Project: 57 Inlet View
Location: Sanford, NC
Company: Freys Building and Remodeling
Care Of: Jeff Greer
Subject: Structural Review

REVISED 2-26-21

**PROPOSED
FOUNDATION PLAN**

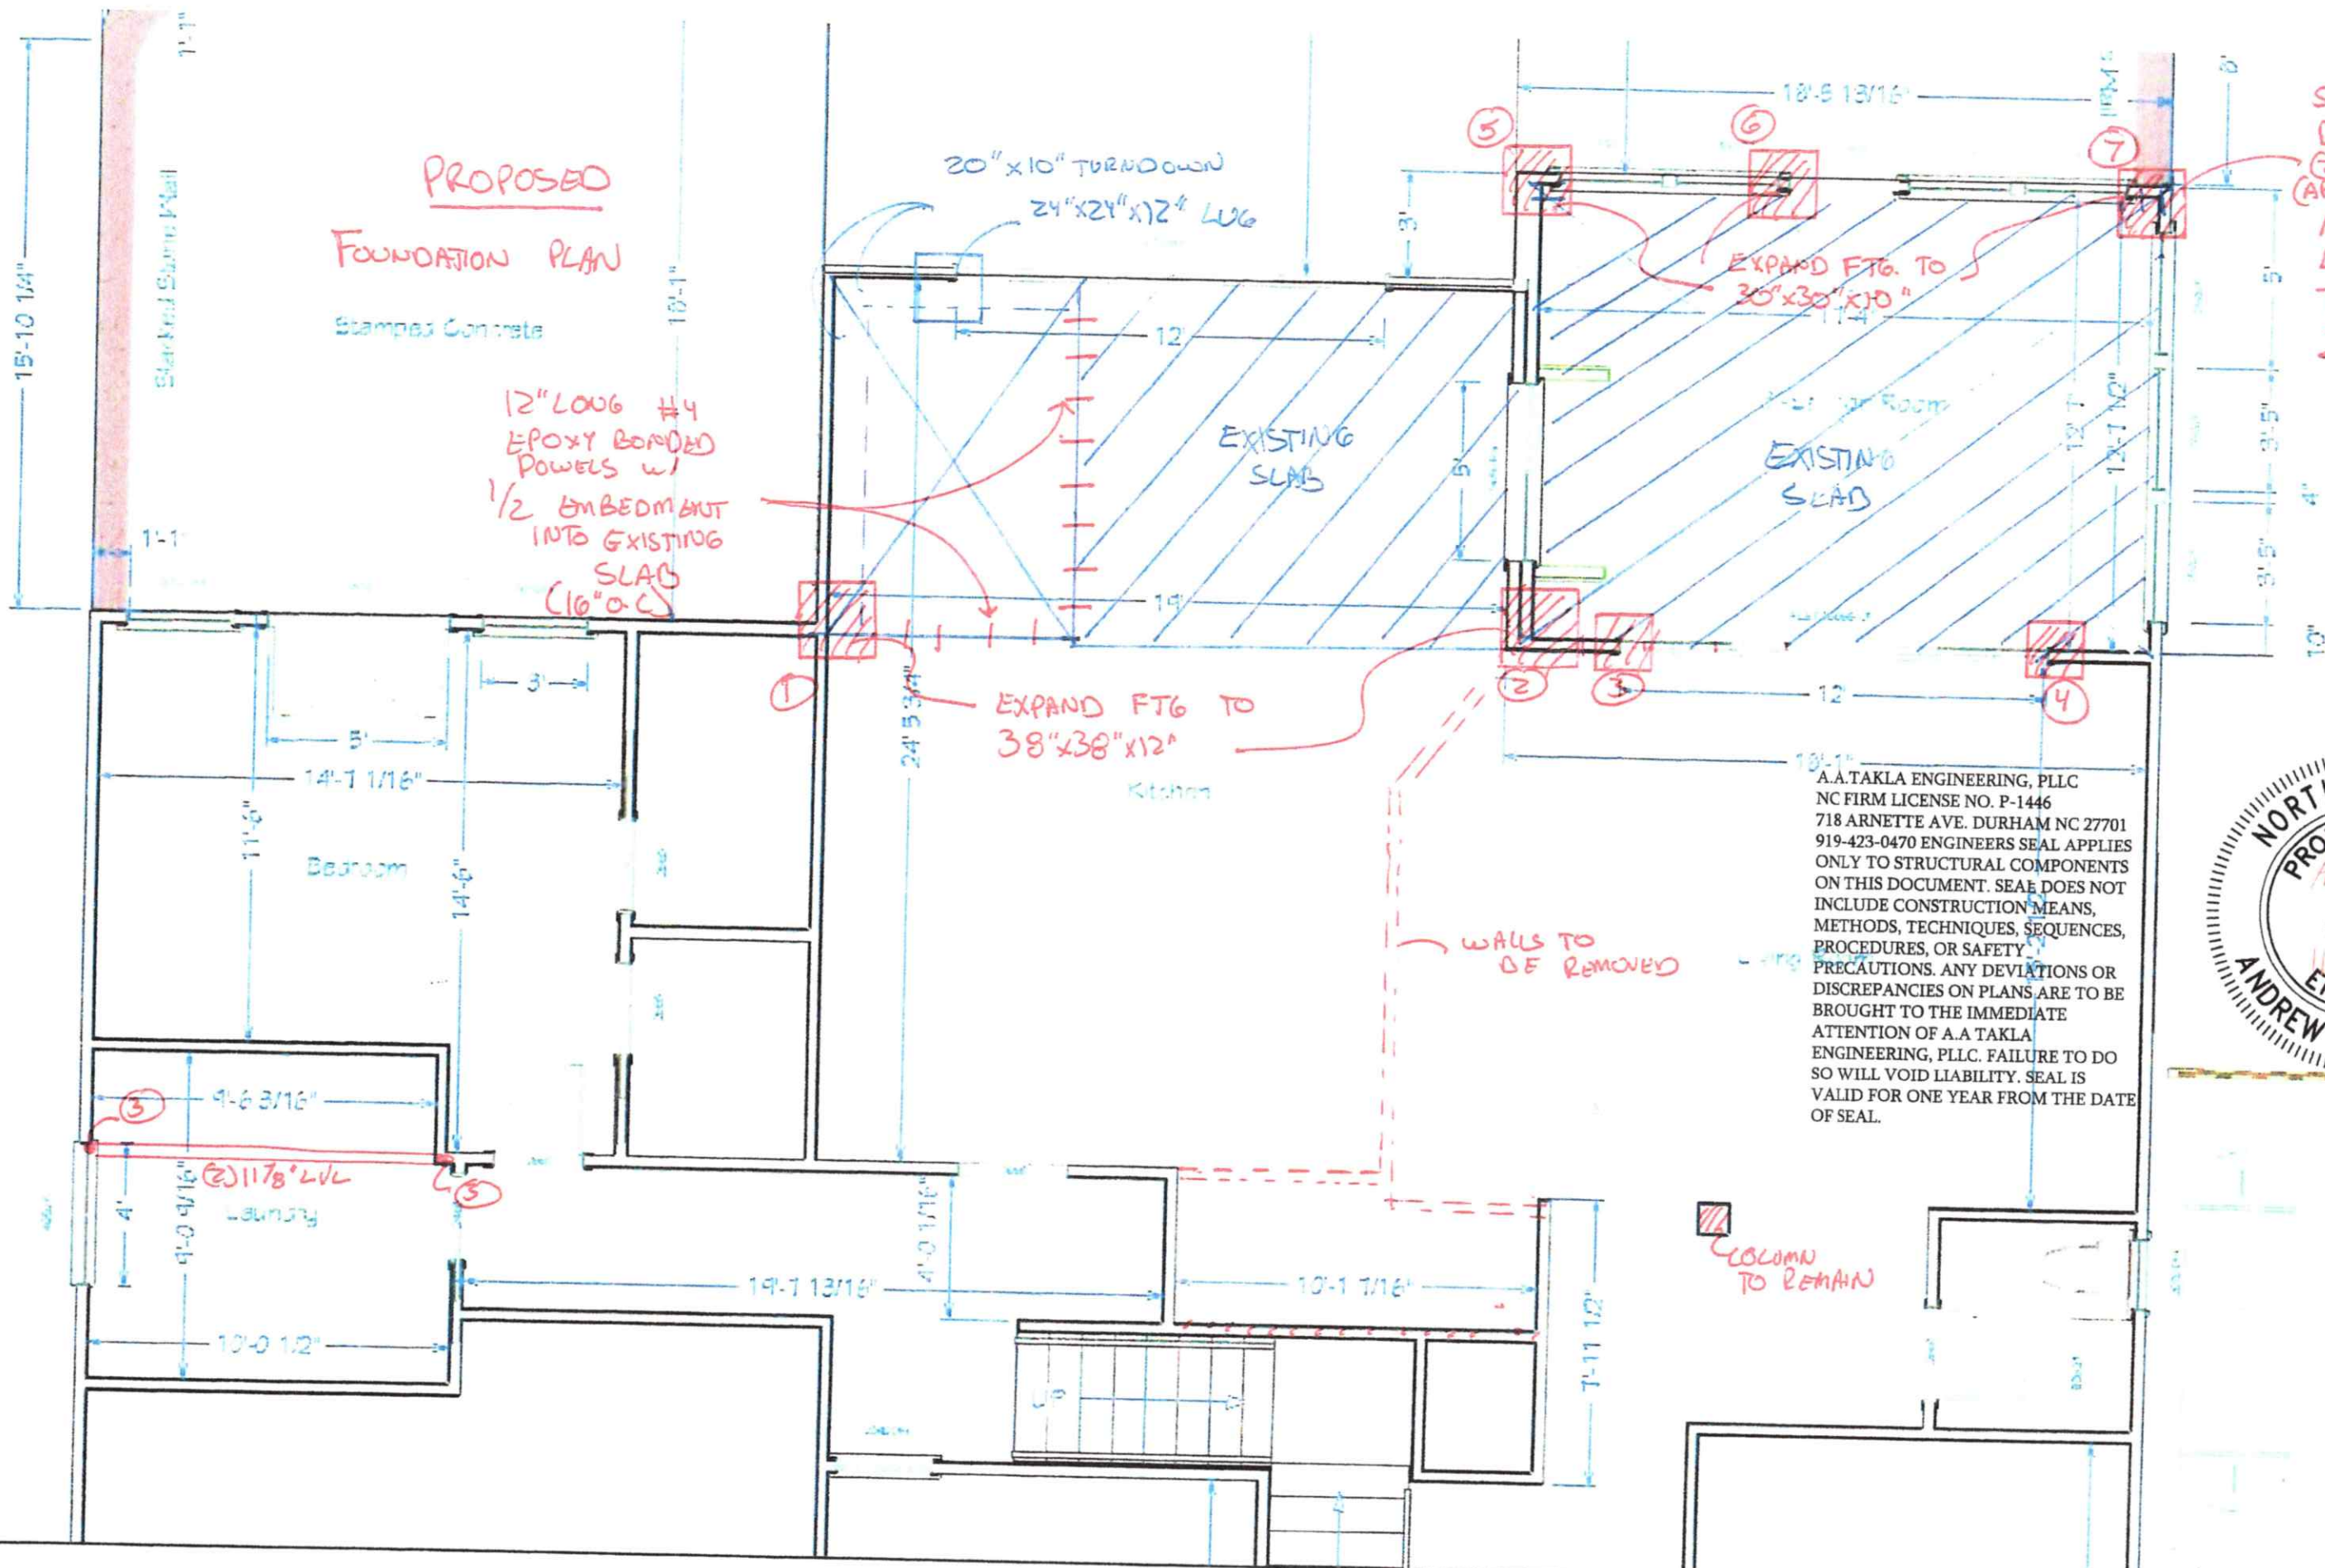
- 1) Left (newly added) portion of the slab at the rear kitchen bump out was evaluated. We understand the slab was not inspected prior to placement of concrete but the lug footings were inspected and verified. The primary issue observed is the lack of embedment of the left bump out slab turndown (essentially sitting on grade).

- 6) Rear porch of rear covered patio slab was also poured prior to inspection. However, given the evidence of reinforcing dowels and the lack of any inducing loading (essentially only dead load of rear wall), we feel comfortable accepting conditions as-is.

- a) To remedy, we recommend undermining left turndown such that bottom of newly added footings are no less than 12" below grade and at least 16" wide. Ideally, the concrete used to enlarge the turndown would be monolithically poured with / to patch the slab (cut to rework underslab services).

- b) **2" foam insulation normal placed around slab on grade foundations is not required in this application.**
- 2) New I-joist spanning over the living room/ kitchen area (replaced due to a break over a since removed wall) is suitable to carry the loads. Note, some minor sheet rock cracking in the right wall of the mater bedroom *may* occur as the joists deflect under a new effective span. Such cracks would be considered primarily cosmetic in nature and need not be cause for alarm; However, if intolerable, reinforce the I-joists by packing out at least one side of each I-joist under the wall (per plans).

2nd STORY FLOOR /
 1st STORY CEILING PLAN
PROPOSED

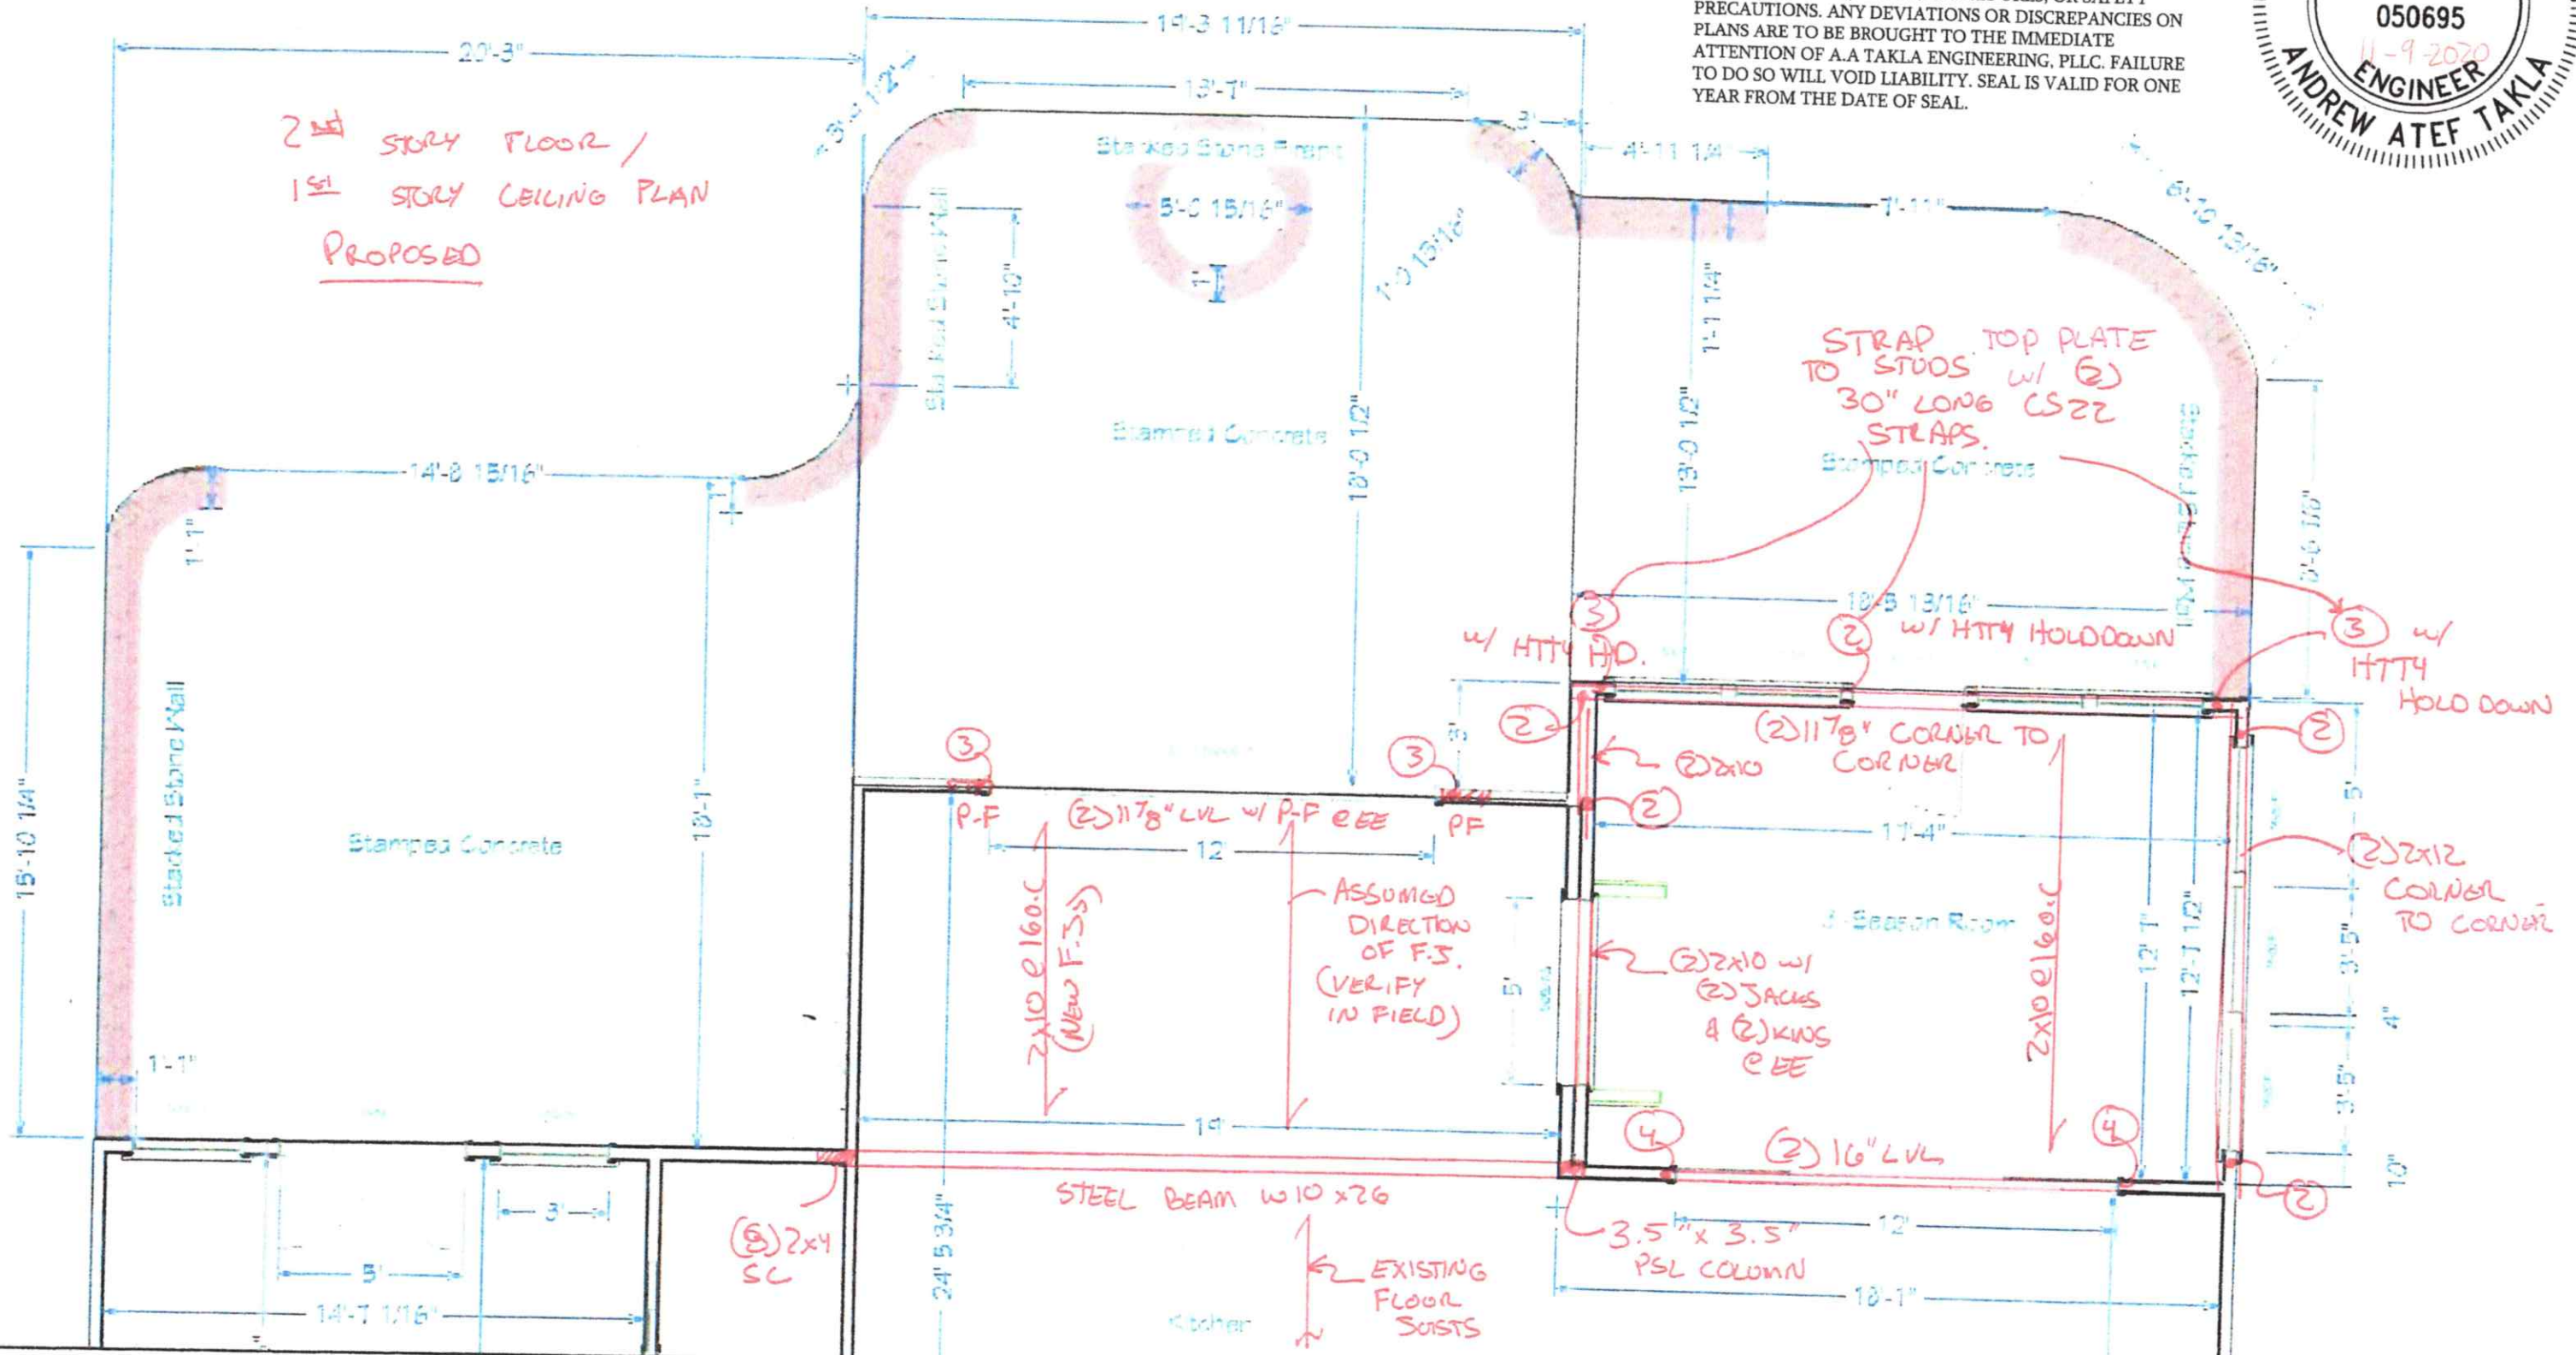
- 3) The hanger connecting the intersecting beams (2)20" LVL and (2) 9 1/4" LVL in the master bedroom was evaluated. In-place hanger (HUGS412) is adequate to carry the loads despite 1.5" long nails being used (instead of 3" long nails). No change is required.
